### **MEMORANDUM**

TO: All Staff  
FROM: Kelee Hodges, Engineer Tech II on behalf of Justin Turnbull, County Surveyor  
DATE: June 16, 2022  
SUBJECT: County Survey Review of BL-22-00012 Miller

MILLER PROPERTY

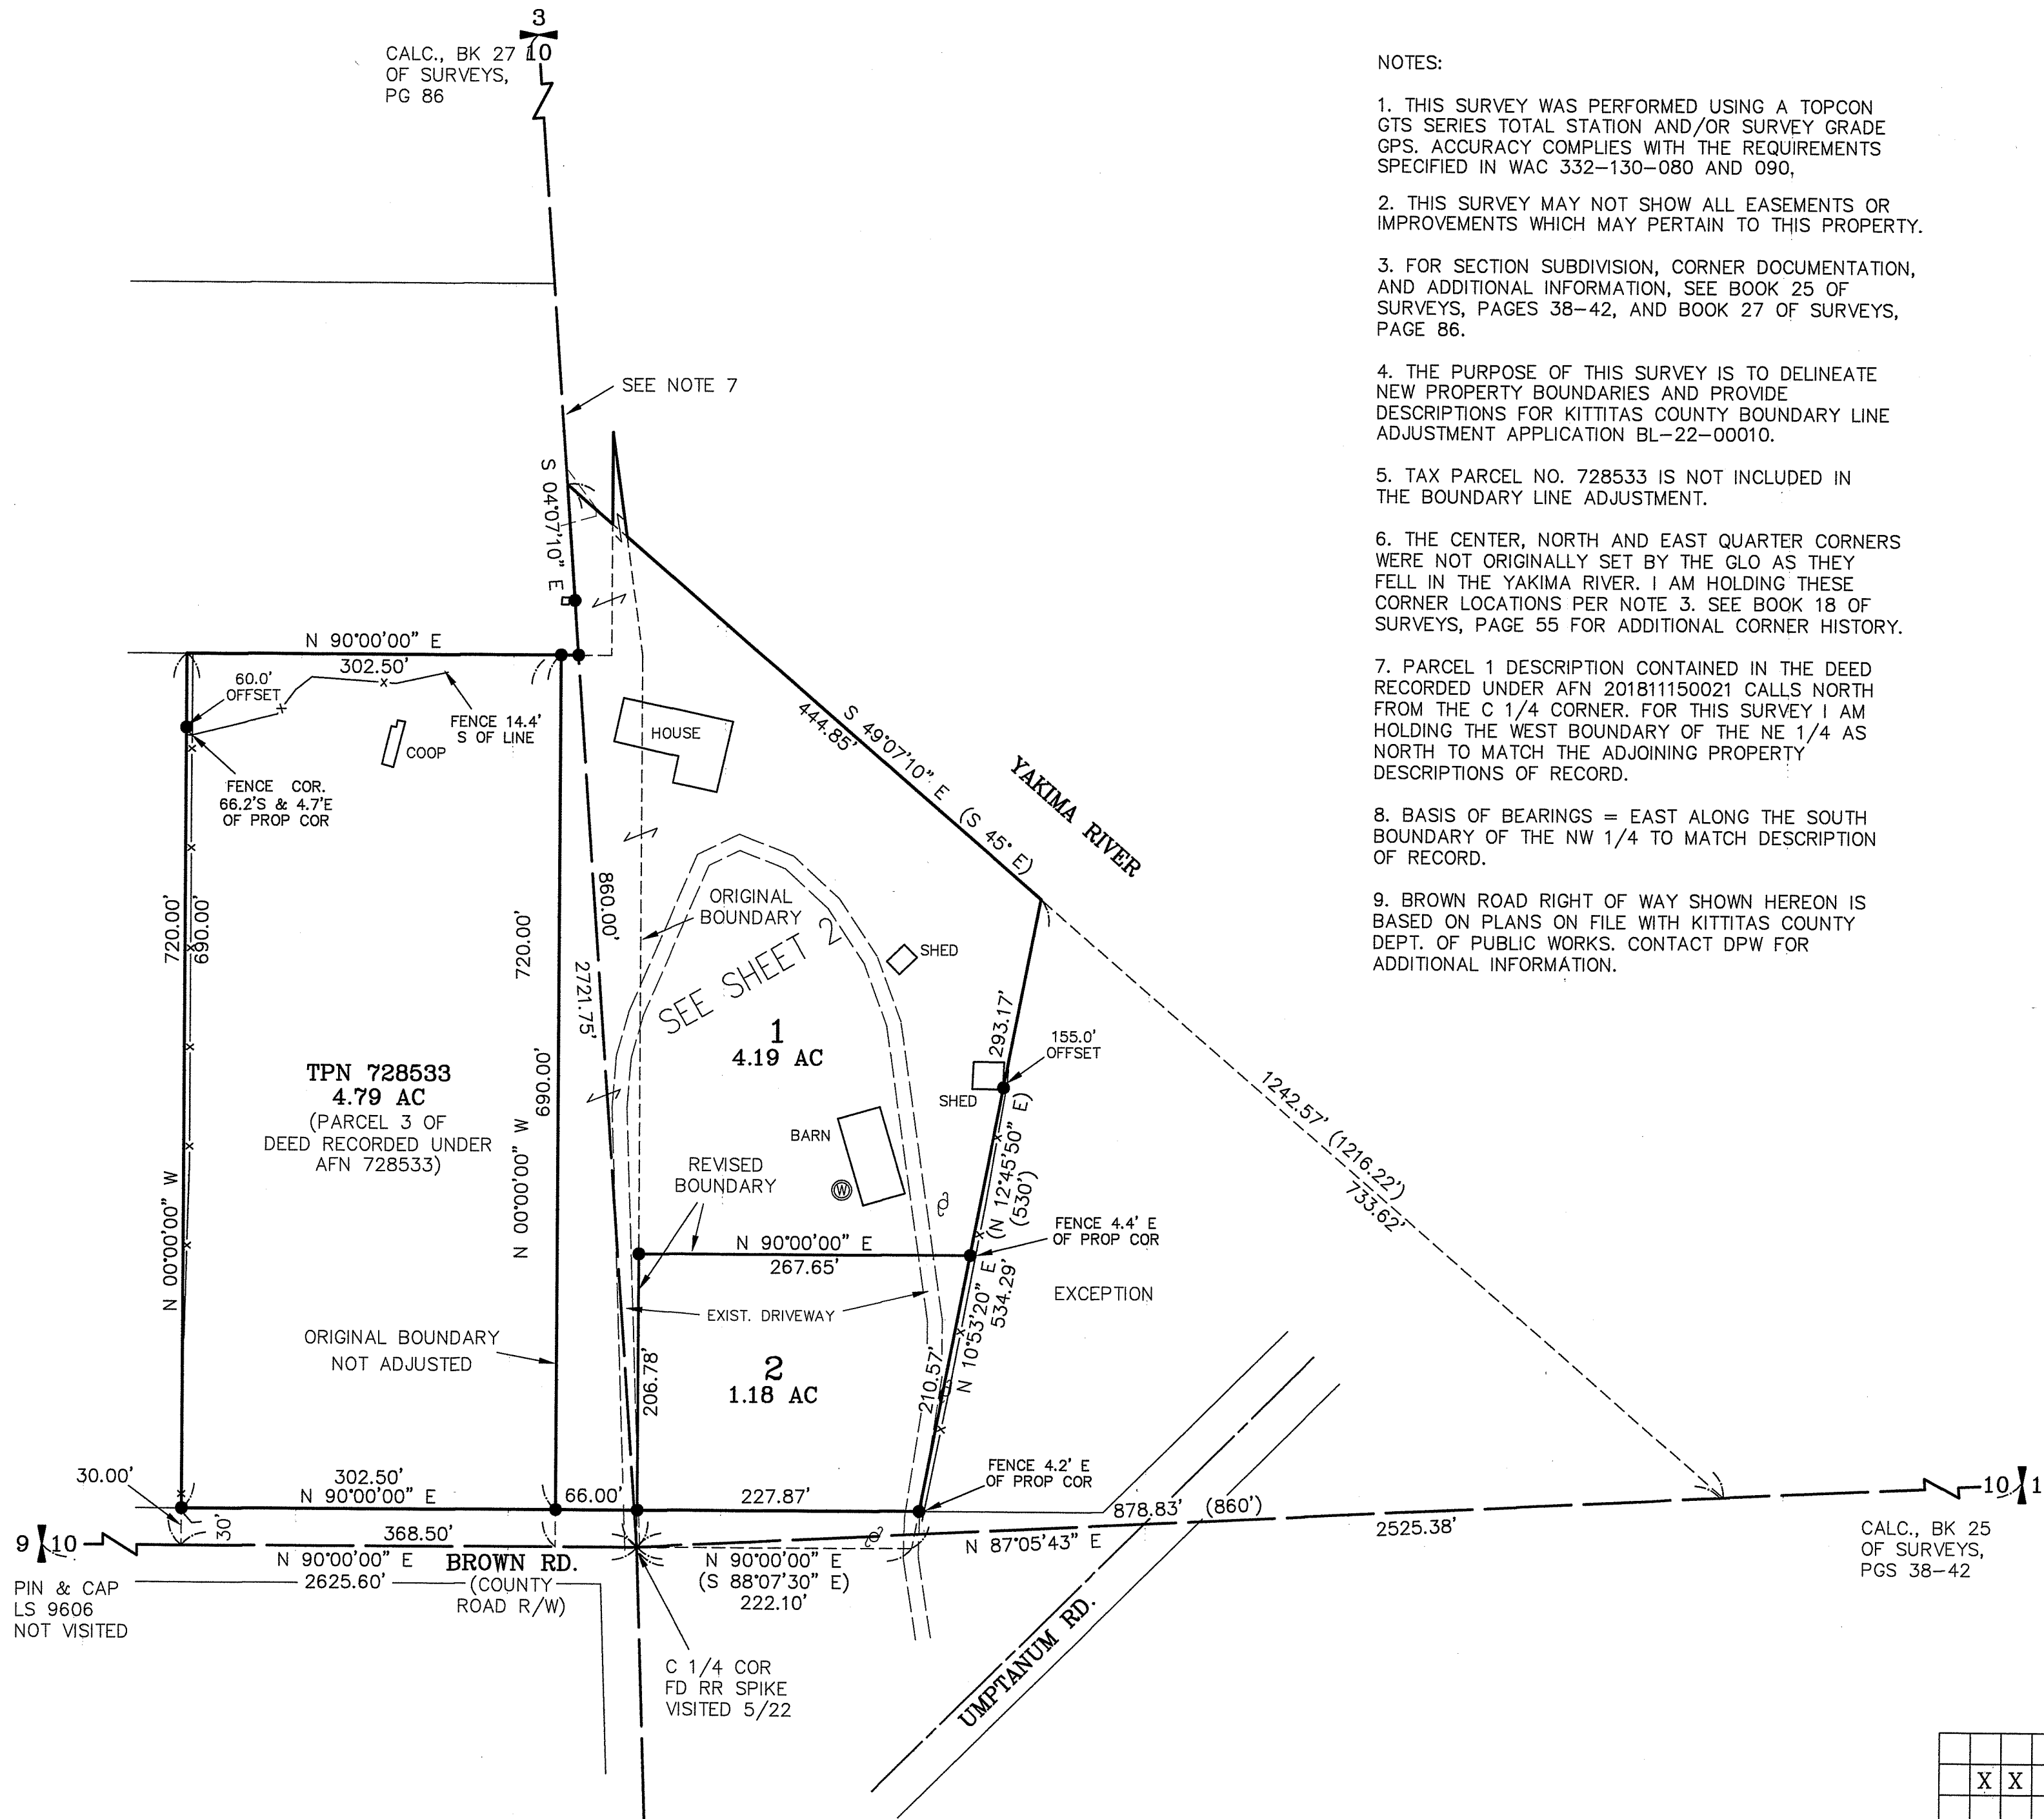
1. All roadways must show name, width, underlying ownership, easement or right of way and surfacing material.
2. Identify all corners used to control the survey per (WAC:332-130-050(1)(f)(ii))

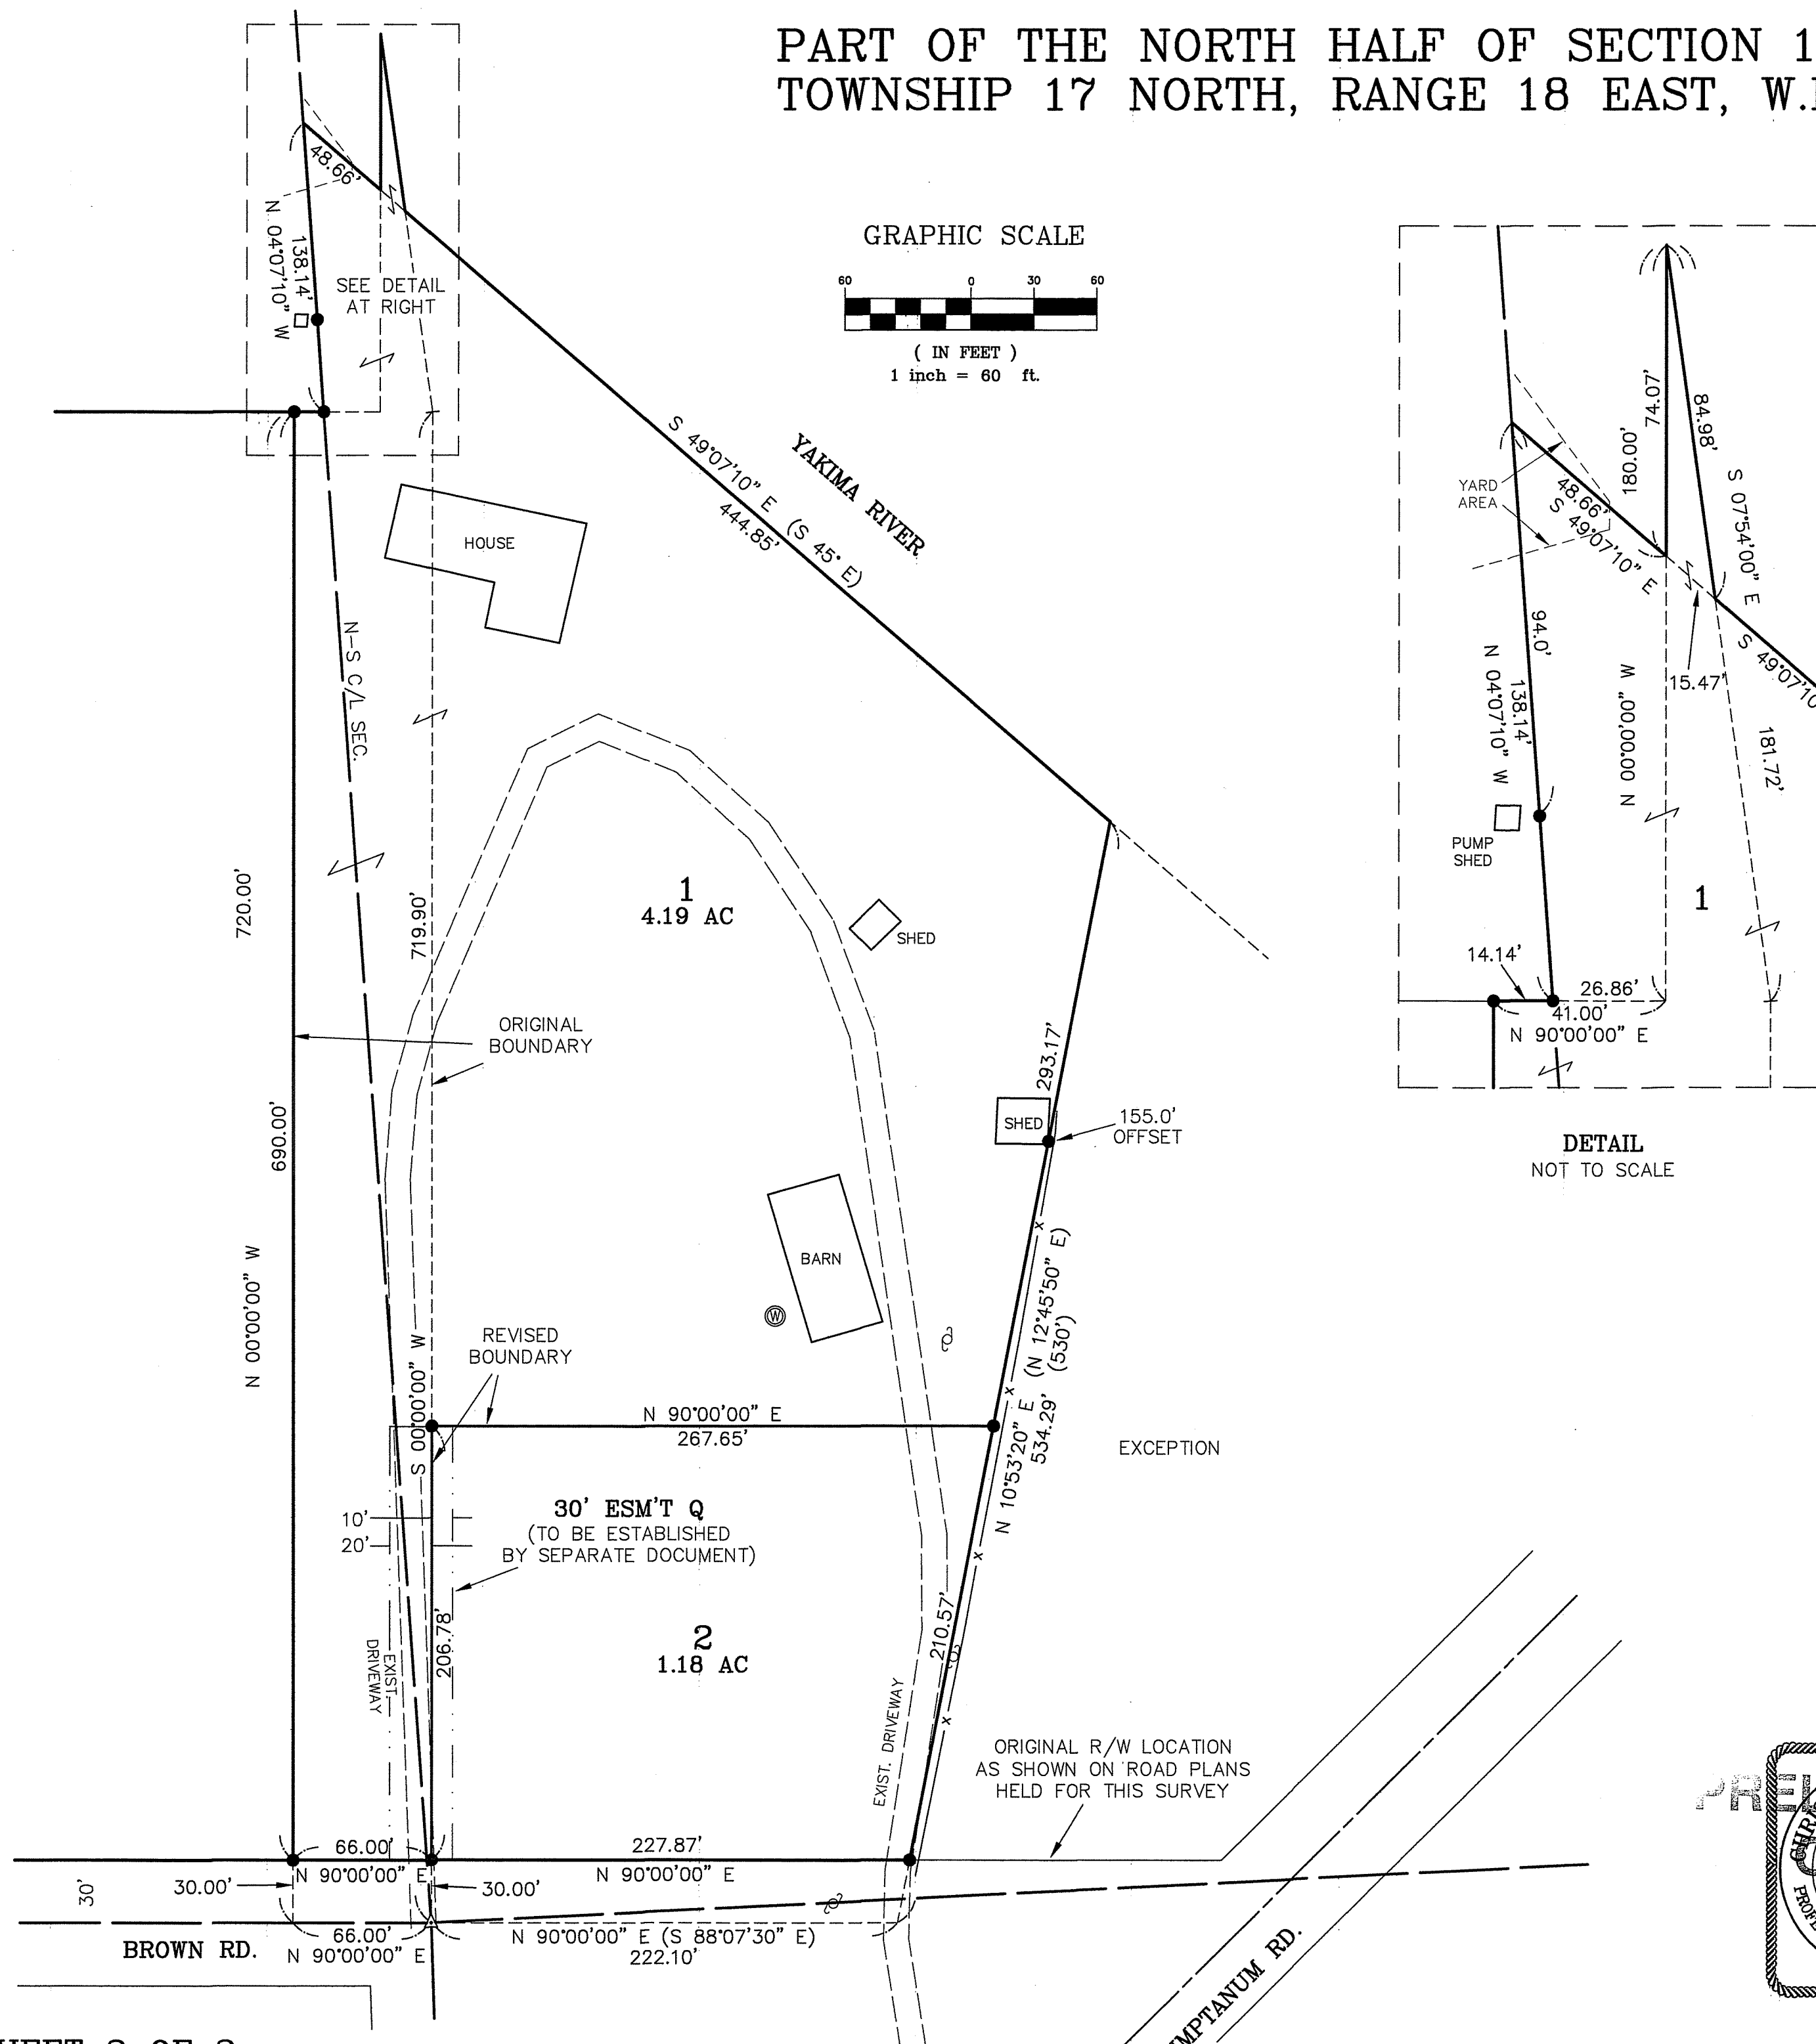
1. Legends do not match on Sheet 1 and Sheet 2.
